Remediation of Hickson Road, Part of EPA Remediation Site 21122, Barangaroo Central (SSD 6617)

Response to Submissions, February 2016

Appendix A: Summary of Submissions and Responses to Issues Raised in Submissions

Figure 4 Sensitive Receptor Locations – Site Boundary

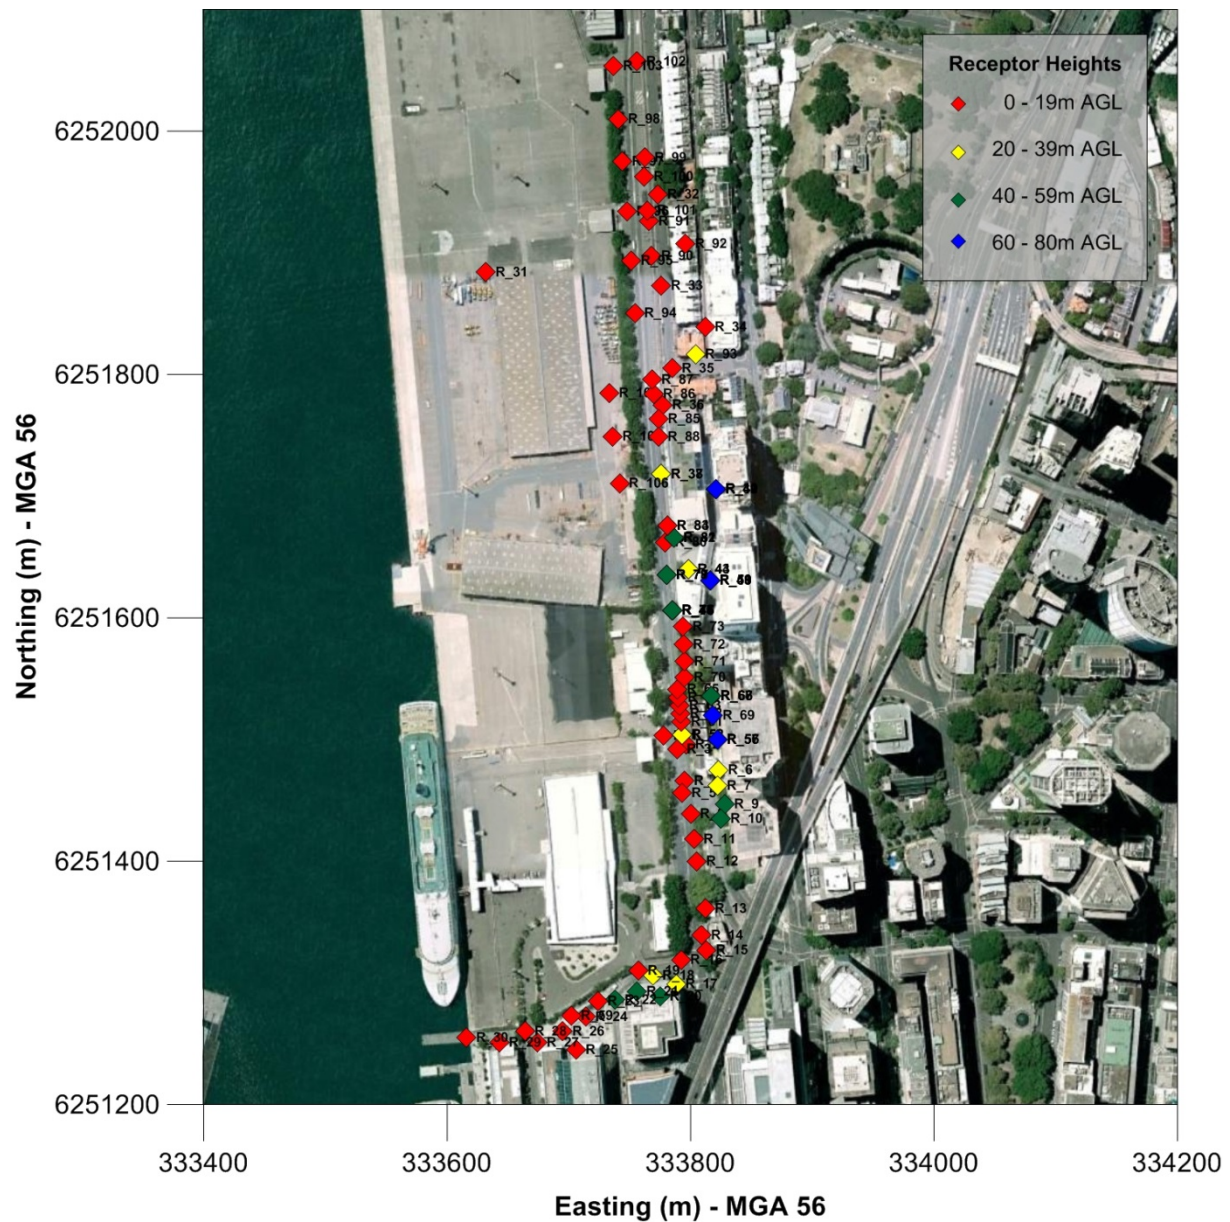
Issue no.	Key Issues Summary	Lendlease Response
	EPA recommends that Conditions of Approval include the requirement for the proponent to develop and implement a comprehensive asbestos management plan for the Project. The plan must include measures that will ensure any asbestos encountered inside the Project emission enclosure is managed in a way that prevents the generation of airborne asbestos fibres.	
15	Additional information and clarification is required to demonstrate potential receptors located within the Barangaroo site have been adequately considered. EPA recommends that the proponent clarifies the locations of the additional receptors assessed in the AQIA, and to demonstrate all potential sensitive receptors have been adequately considered in assessment of air impacts.	Refer to Figure 6 in the amended AQIA (Appendix E) which shows the general location of the receptors included in the modelling.
